Westfield House,
Fontwell Avenue,
Eastergate,
West Sussex.
23.08.18

We wish to add further comments to our original letter of objection to Planning Application AL/136/17/PL dated 14.02.18. We do so, for the following reasons:-

PROPOSED SITE PLAN 1:200

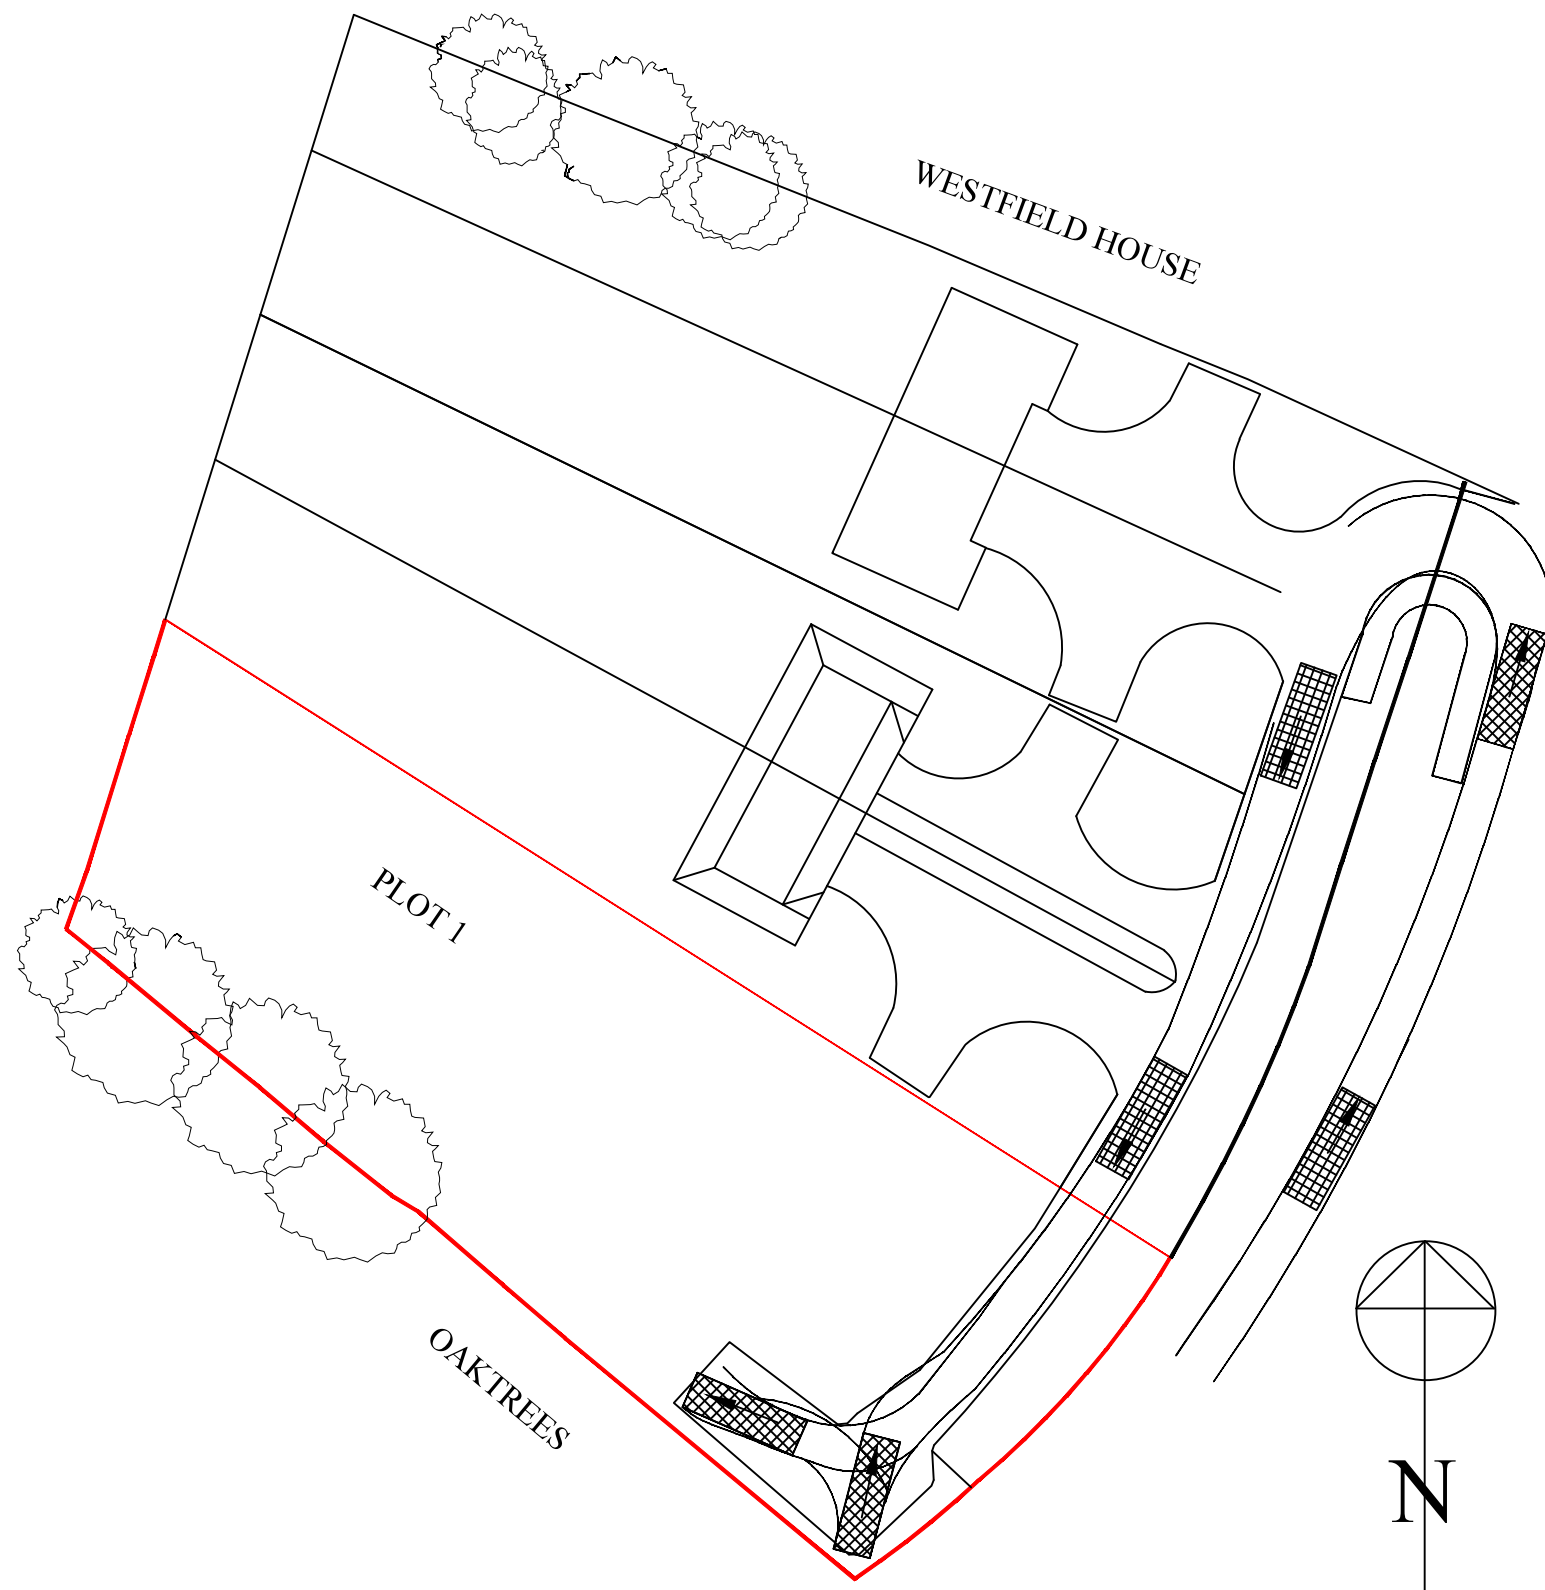
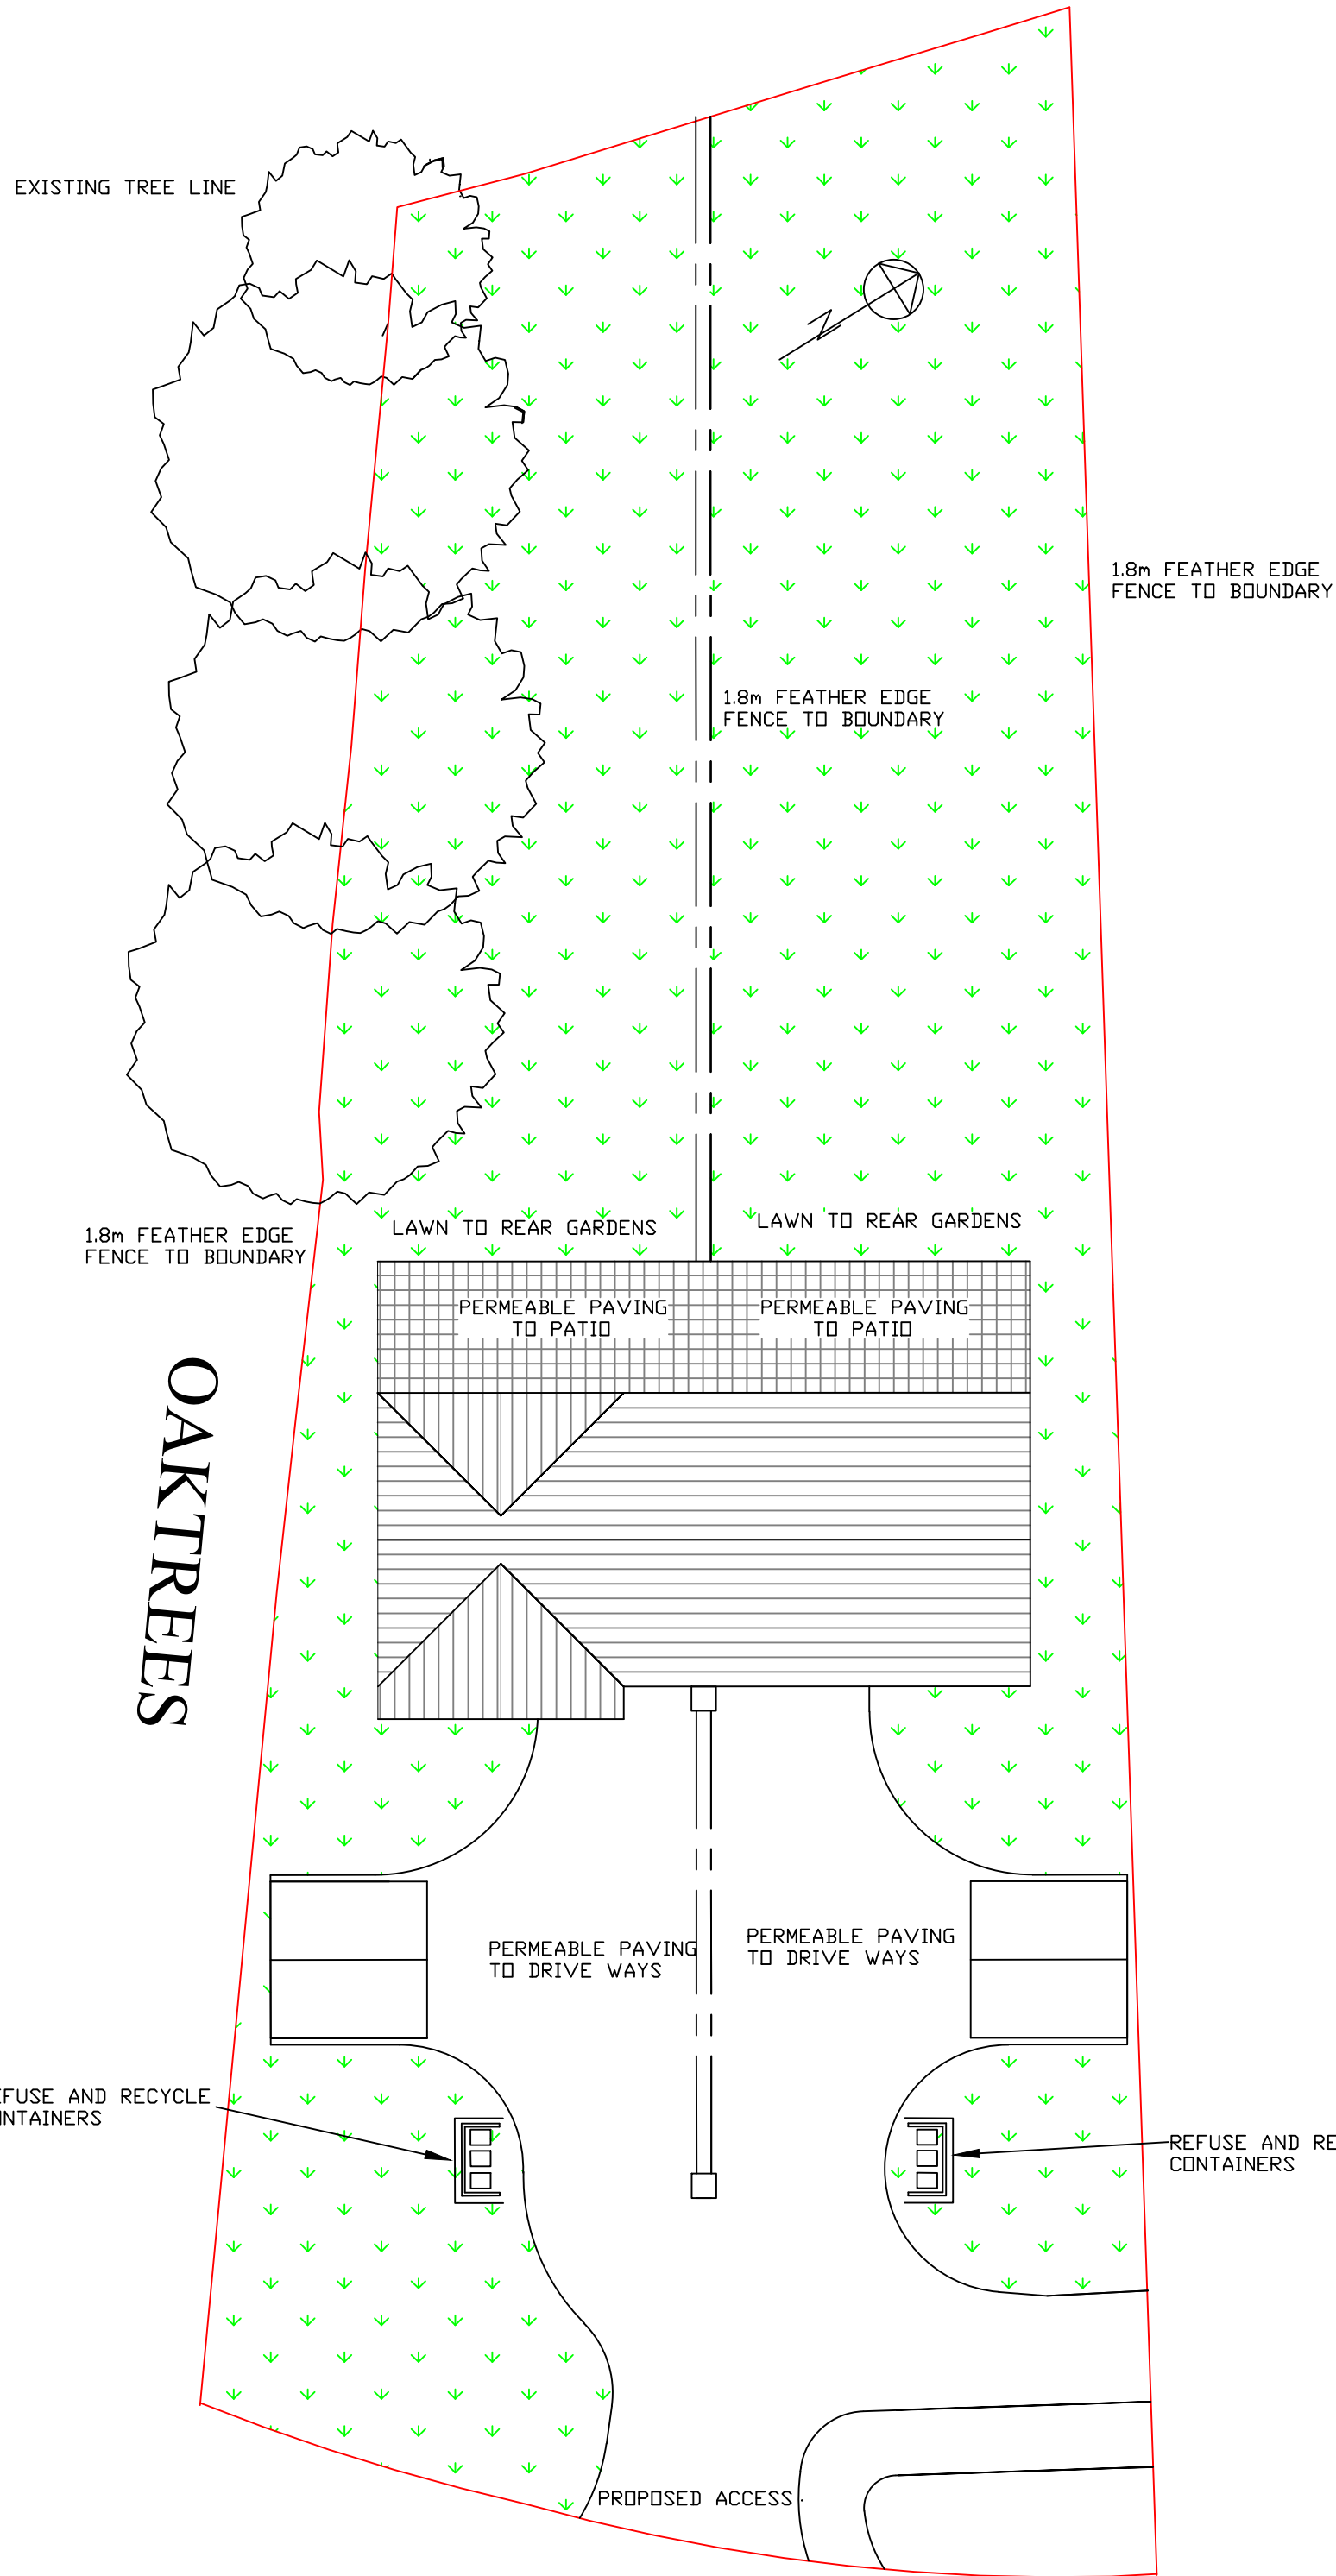
2. The five revisions of the plans clearly indicate the intension to find a way around the rules relating to highway access. (Presently restricted to a total of 5 units.) The provision of an additional access point from the A29 would allow more than 5 units to be placed along it. However- there are three separate sites here, belonging to three different owners, registered and clearly shown on the Ordinance Survey Map. - WSX375039 Mr. and Mrs. Duggin, 28.10.16, WSX375044 Mr. Norgate 22.09.15 and WSX375045 Mr. Parker 22.09.15. None of these titles show any kind of right of way either pedestrian or vehicular across them. **Therefore the road which is proposed would require permission from each owner for the other owners to cross their land.**

3. There has been much discussion in the numerous documents entered on the web-site about visibility splays. This has been the reason for the numerous revisions of the plans, but also the reason that planning applications have been refused in the past. These numerous drawings have tried to address the issue relating to the lack of sufficient visibility around the curve in the road (A29). The latest plan (on paper) shows that the applicant has simply moved the boundary with Mr. Norgate's land, to achieve his purpose. This may or may not be with Mr. Norgate's permission and may address the regulations on paper, but there is no legal agreement in place relating to this, it will not change the actual topology of the site, and would not be legally enforceable by yourselves if the actual road is built, because Mr. Parker would have crossed the legal boundary with Mr. Norgate's land.

4. This Planning Application proposes in a one way road system with all traffic entering the site at one end and leaving from the other. In our original letter of objection we questioned the practicality of this arrangement and how it could be enforced. This objection remains, but additionally there is no indication in the paperwork on the web site, that the other two owners of the land are in agreement with this, or will be legally obliged to adhere to this. **In addition to the fact that the three owners must agree to the other two owners (and any other visiting member of the public) having right of way over their land, they must also agree to only moving their cars in one direction.** If there is no legal document agreeing to this, how can the Council add an additional Condition, to the Planning Permissions which have already been granted to Mr. Norgate and Mr. Duggin especially as Mr. Duggin (including his family and friends) has been living on site in a mobile home for the last year and using his one access to enter and leave the site (in a northerly direction) on a daily basis. Why would he suddenly exit to the south and then turn northwards to continue his journey to work? If this application is granted, there will be traffic entering and leaving from both access points which will create traffic chaos and constant complaints to yourselves and the Police because the Planning Conditions will not be enforceable on a daily basis.
